Application Ref:	3/2025/0440				Ribble Valley Borough Council www.ribblevalley.gov.uk	
Date Inspected:	N/A	Site Notice:	N/A			
Officer:	EP					
DELEGATED ITEM FILE REPORT:					Decision	PERMISSION NOT REQUIRED.

Development Description:	Prior approval for cattle building (39.55m long, 3.98m height to eaves, 35m width, 5.94m height to ridge) with covered muck midden and silo including provision of new access road and yard.
Site Address/Location:	Brook House, Hole House Lane, Slaidburn BB7 4TS.

Gross Area = 1090m<sup>2</sup>  
Floor plan  
1 : 100  
0 1 2 3 4 5m

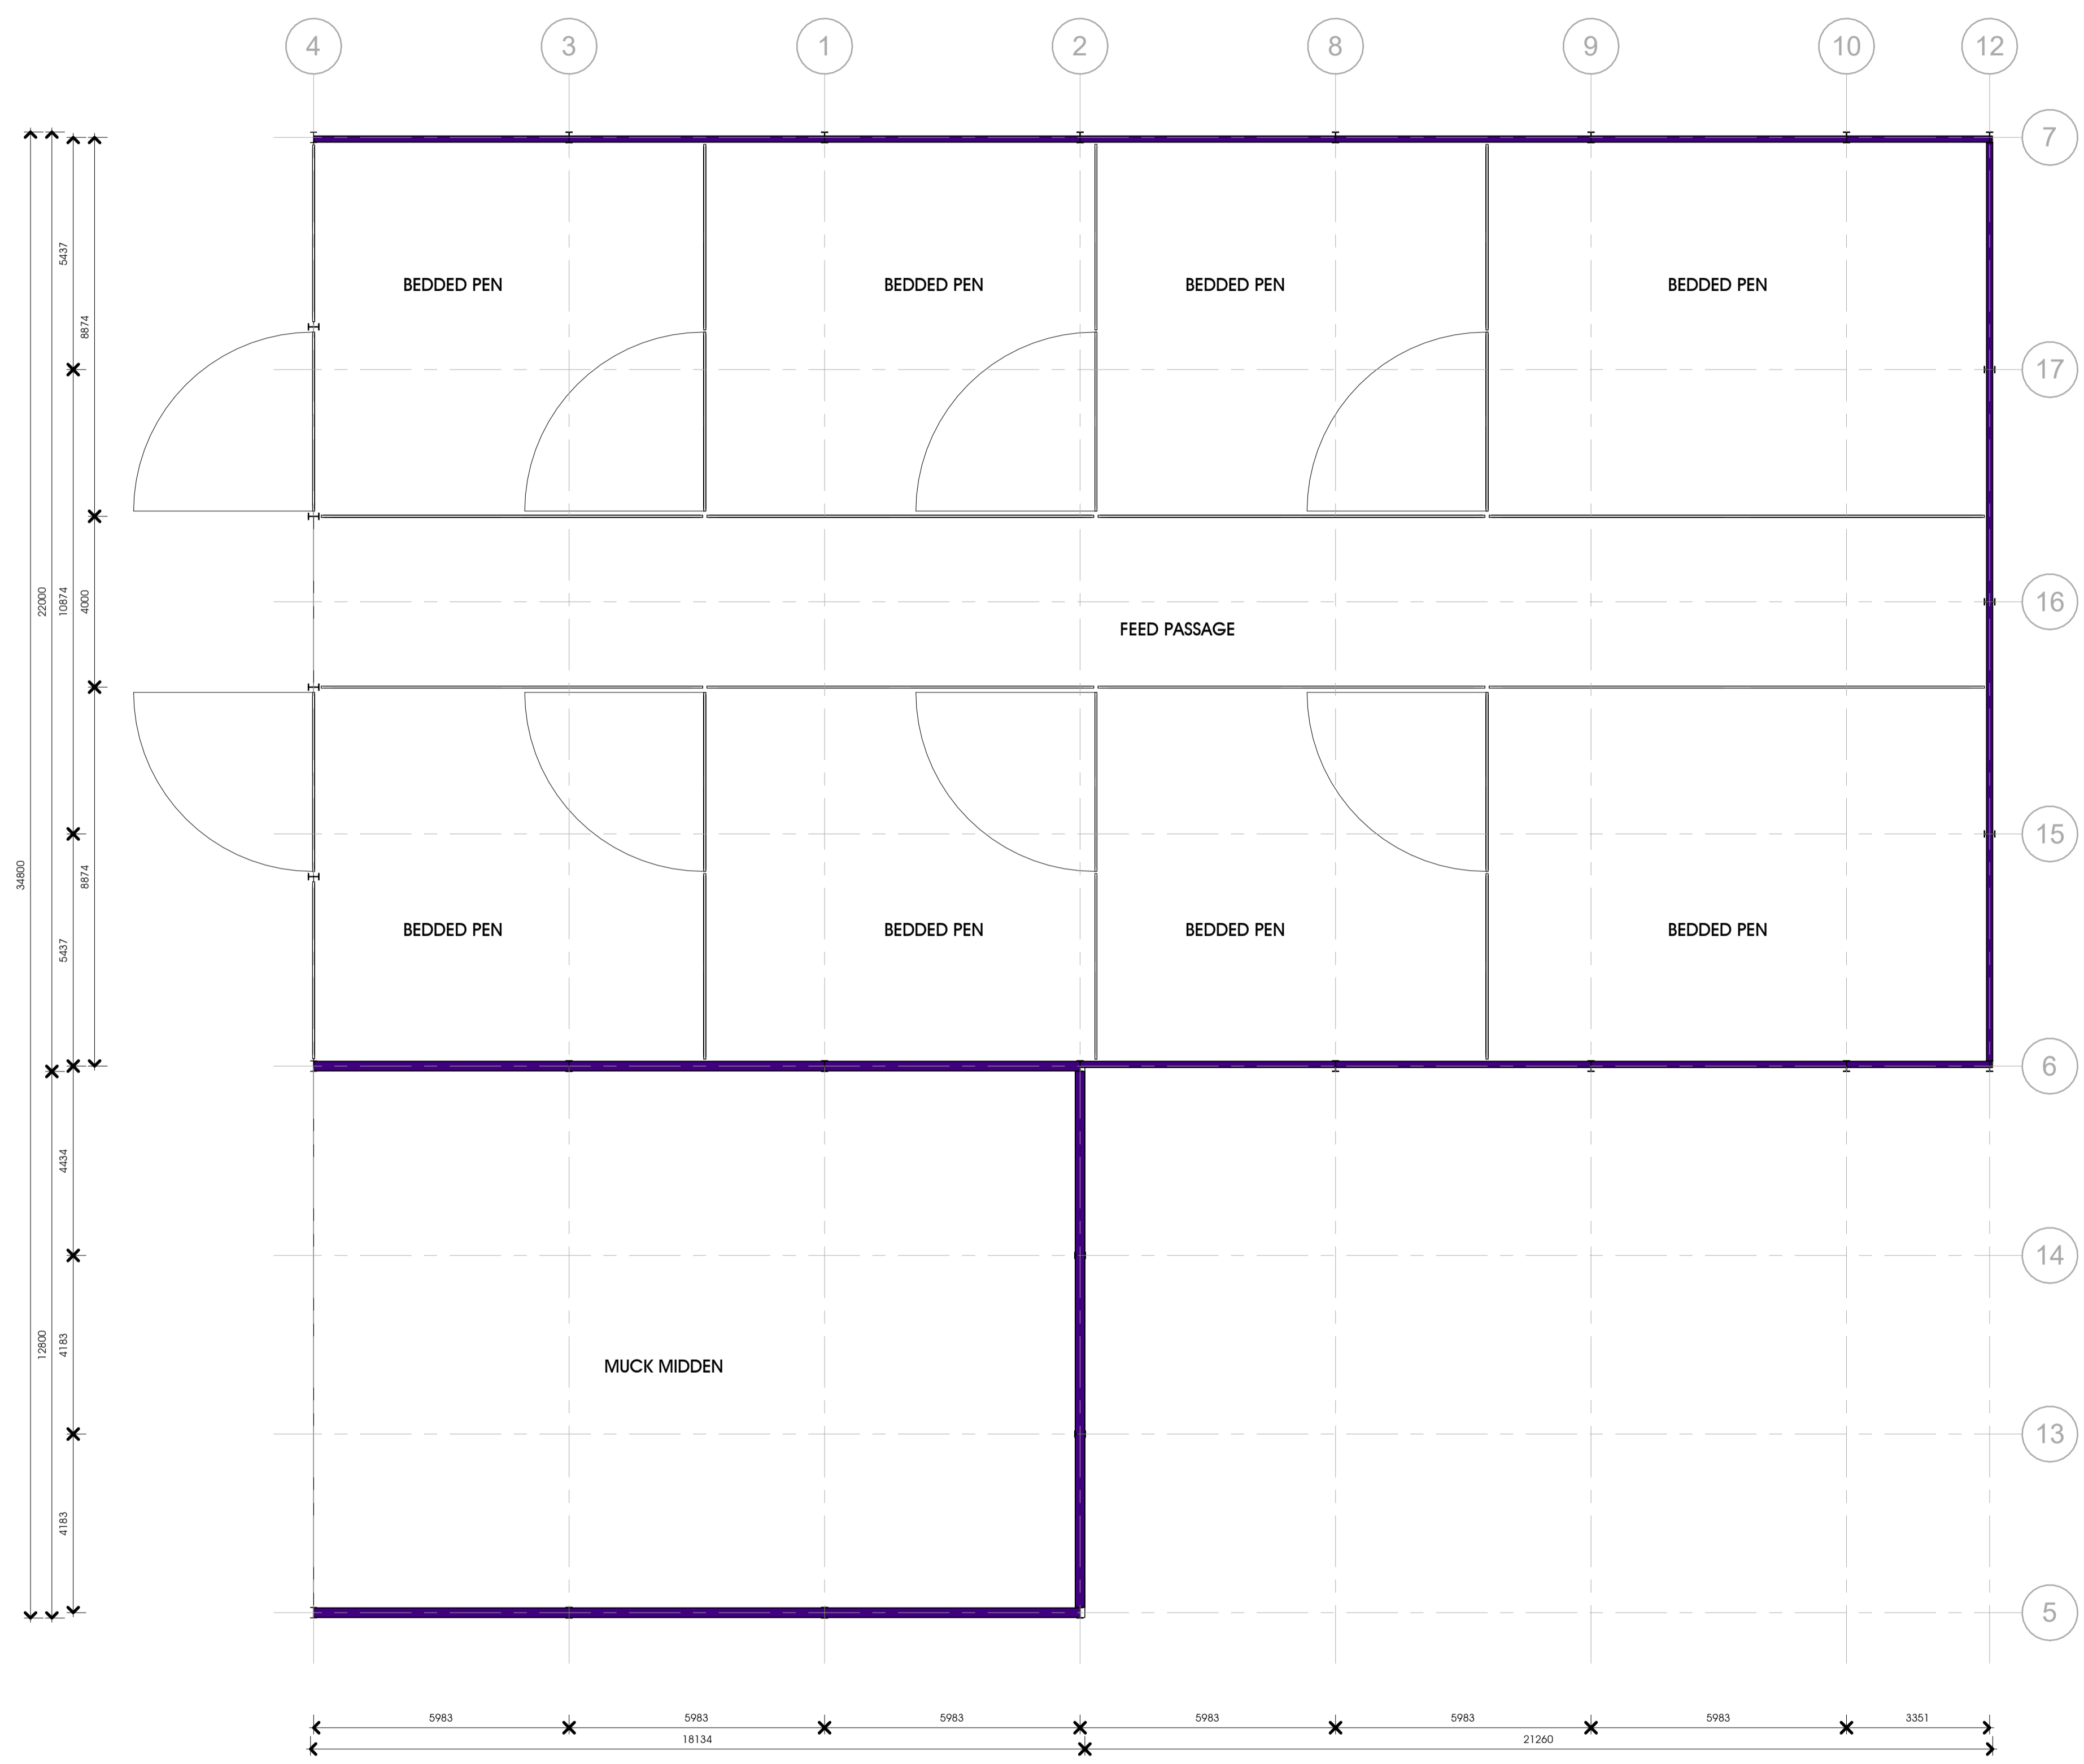
The proposed building to be erected would measure a total of 1108 square metres in area. This exceeds the allowed 1000 square metres for a livestock building of this nature. It is recognised that part of the building is proposed as a muck midden, however, given this section of the building is attached to remainder of the cattle building, the proposal must be assessed as a whole.
